Please ask for: Mrs D Johnson
Email: daun.johnson@arun.gov.uk
Telephone: 01903 737762
Our Ref: AL/12/25/PL
Your Ref:
Date: 11th February 2025

Application for Planning Permission

Development: New permanent building to improve the current water treatment facilities with the construction of a new PRV building. This application is in CIL zone 3 (Zero Rated) as other development.
Location: Portsmouth Water Westergate Wtw Level Mare Lane Westergate PO20 3SB

**Figure 5: image showing impact of PRV building on adjacent grassland**  
**Landscape**

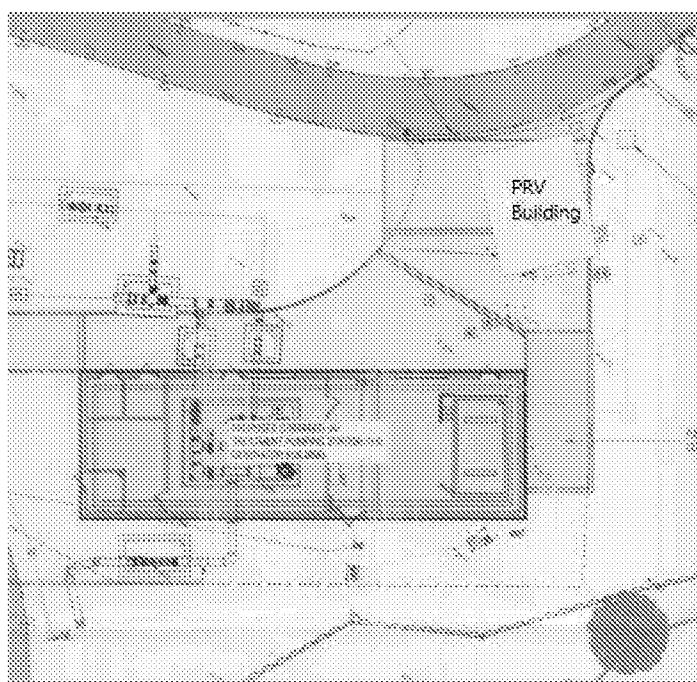
After speaking to our Ecology Officer, he has asked to confirm the area of grass being developed.

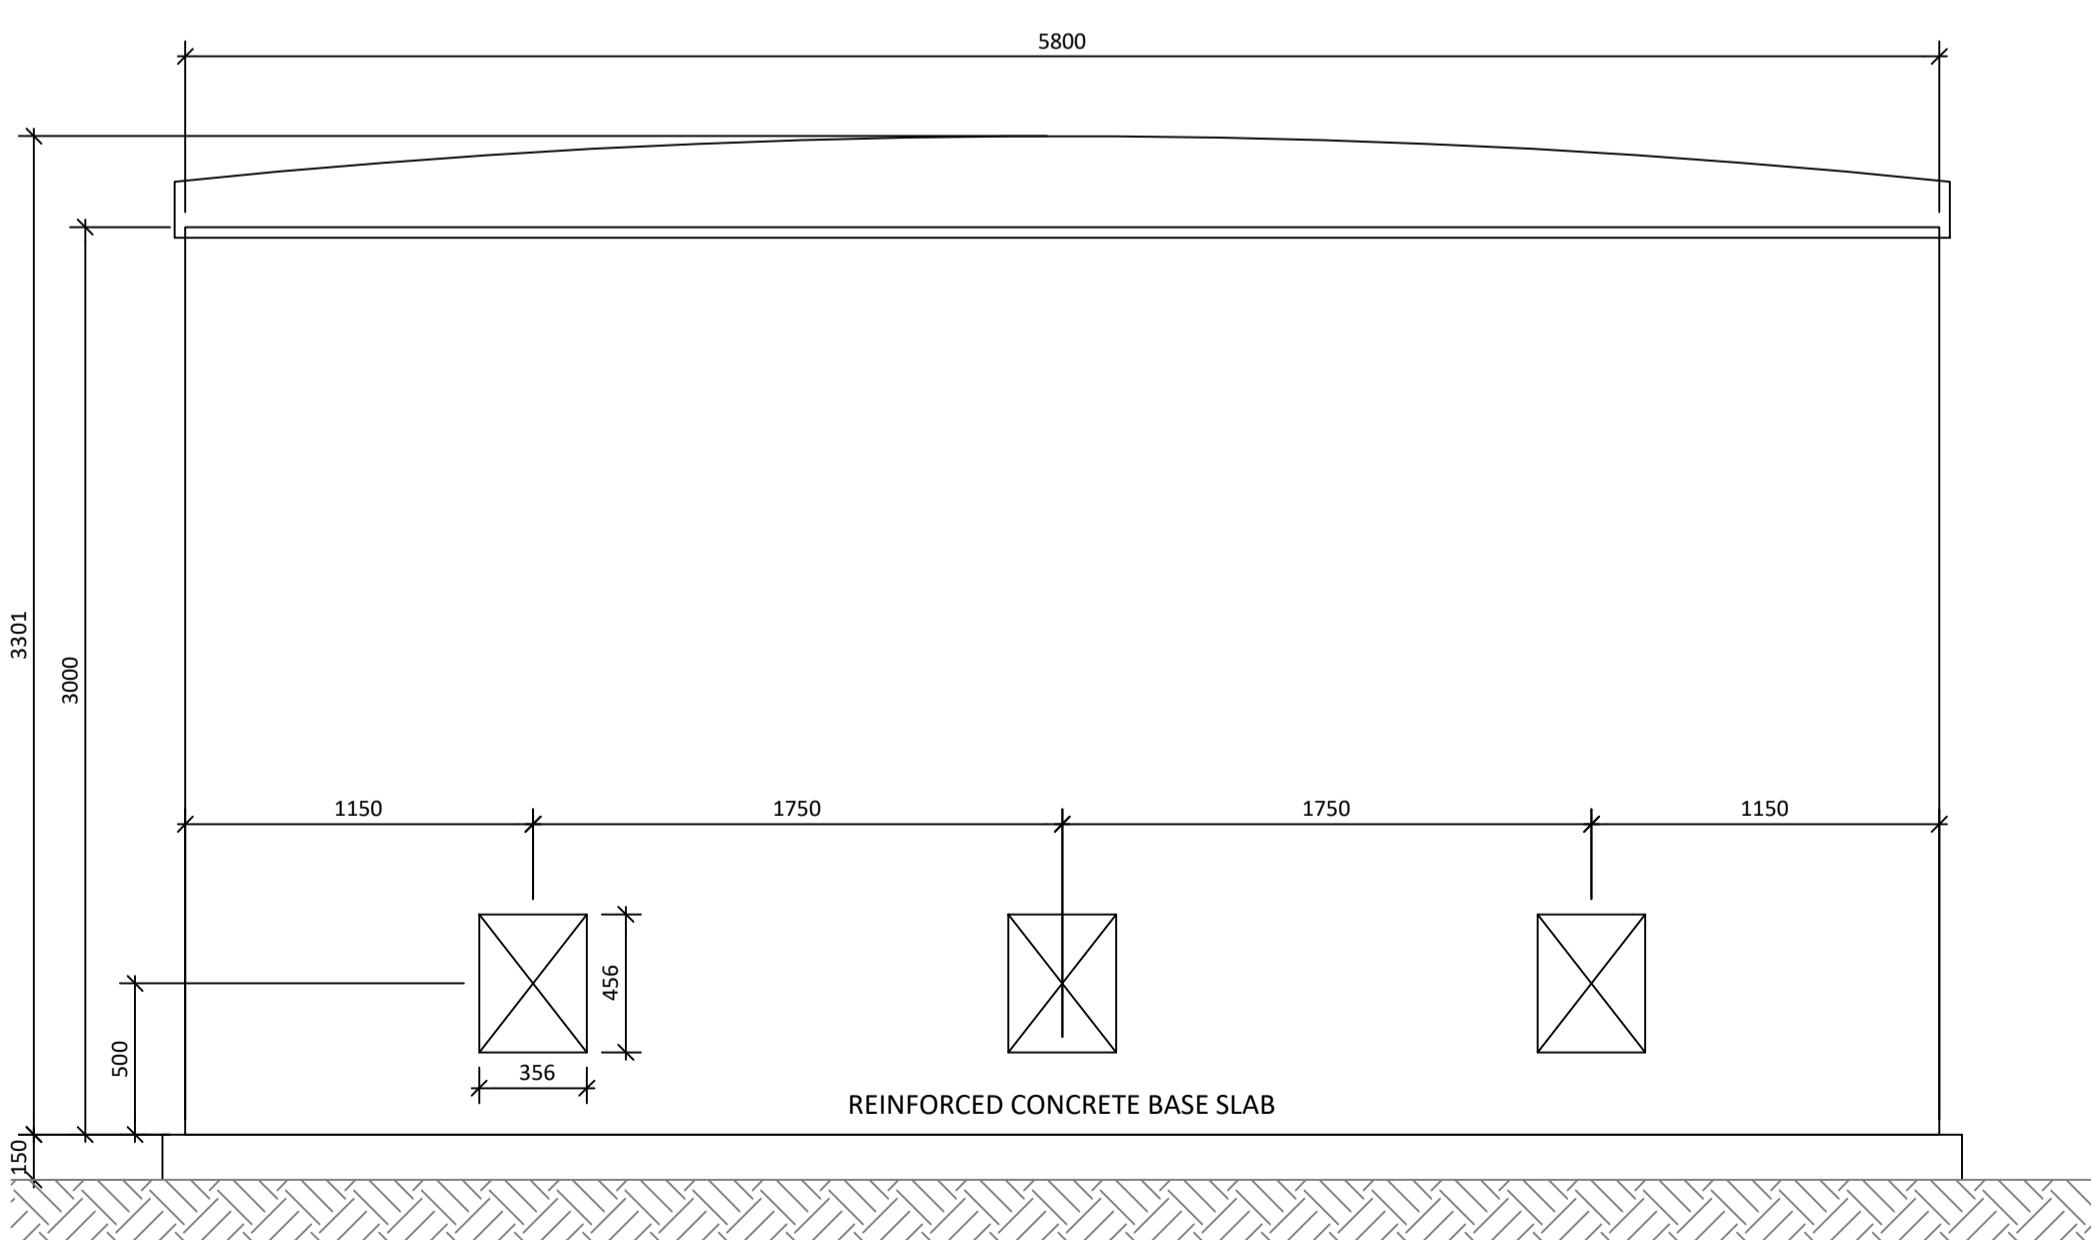
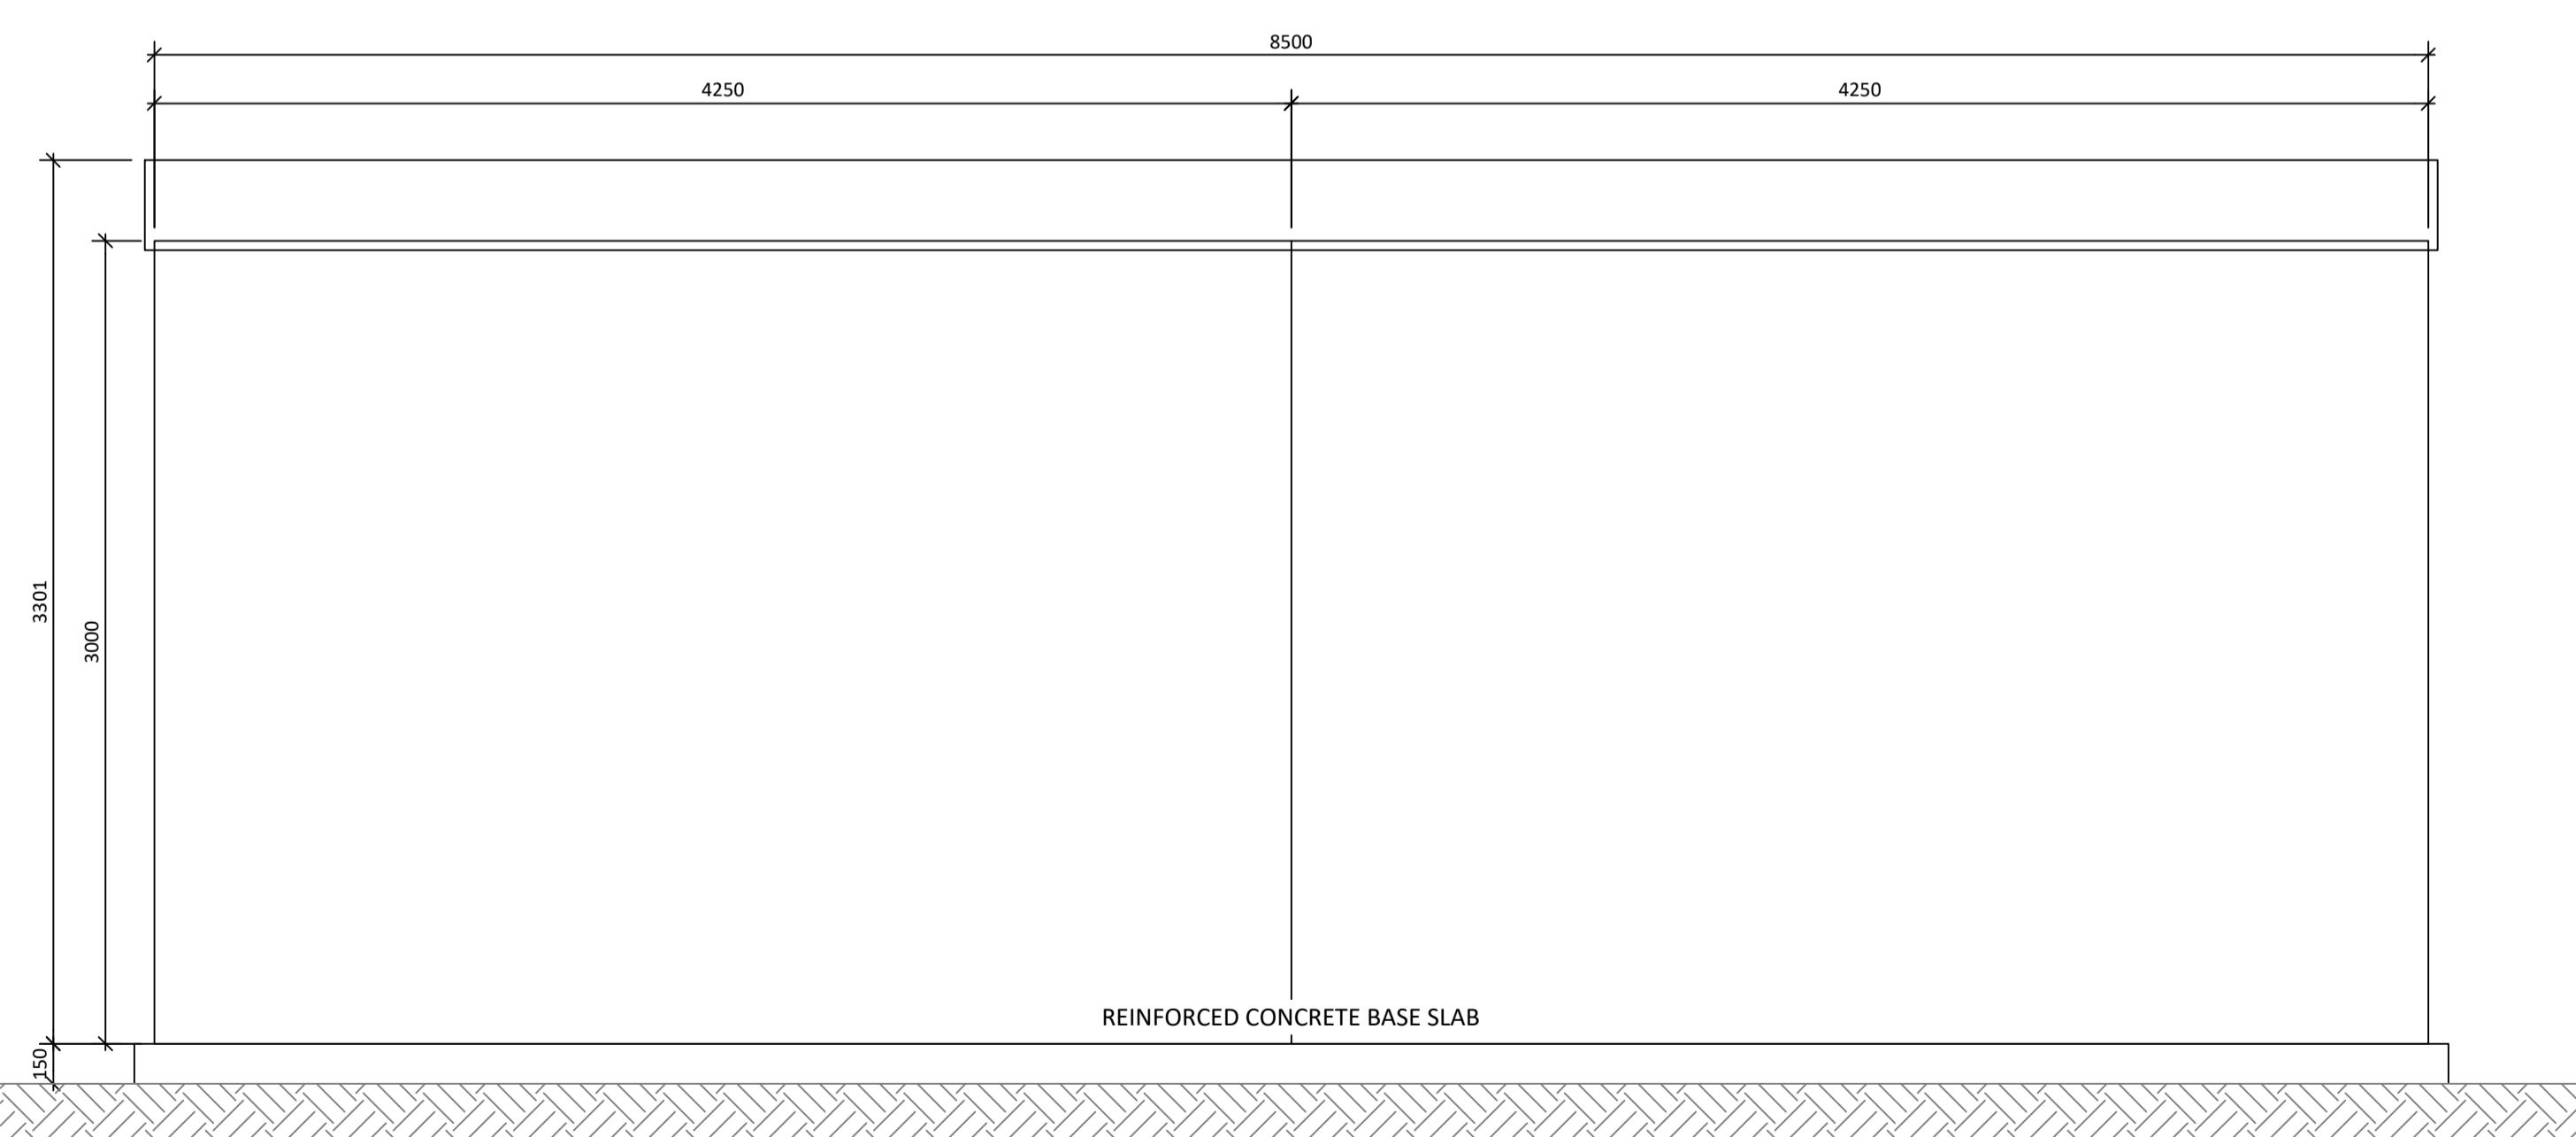
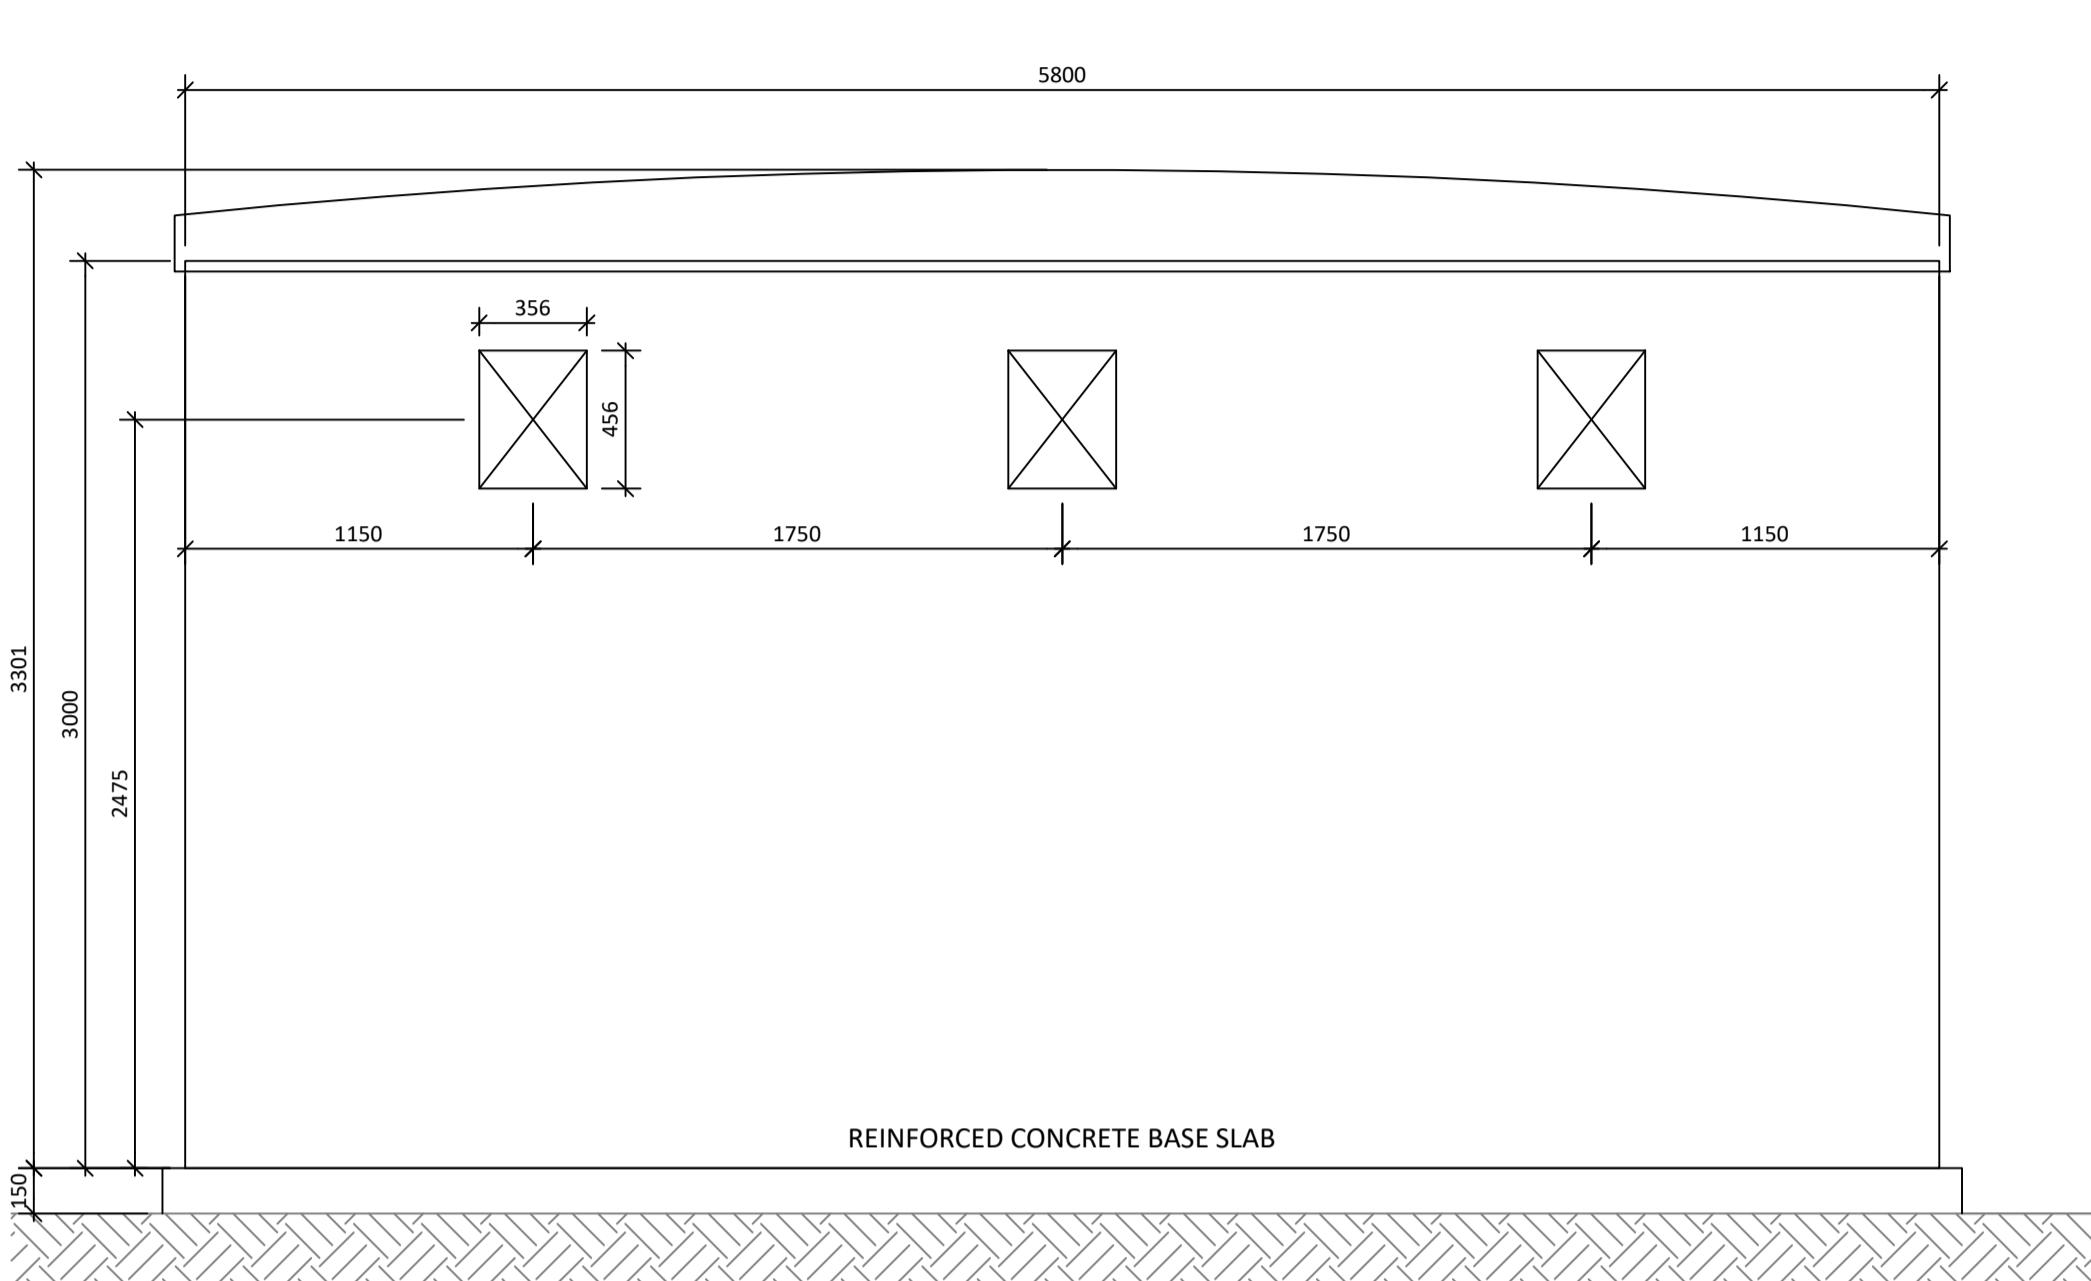
The floor plan and elevations do not scale correctly. Please amend accordingly.
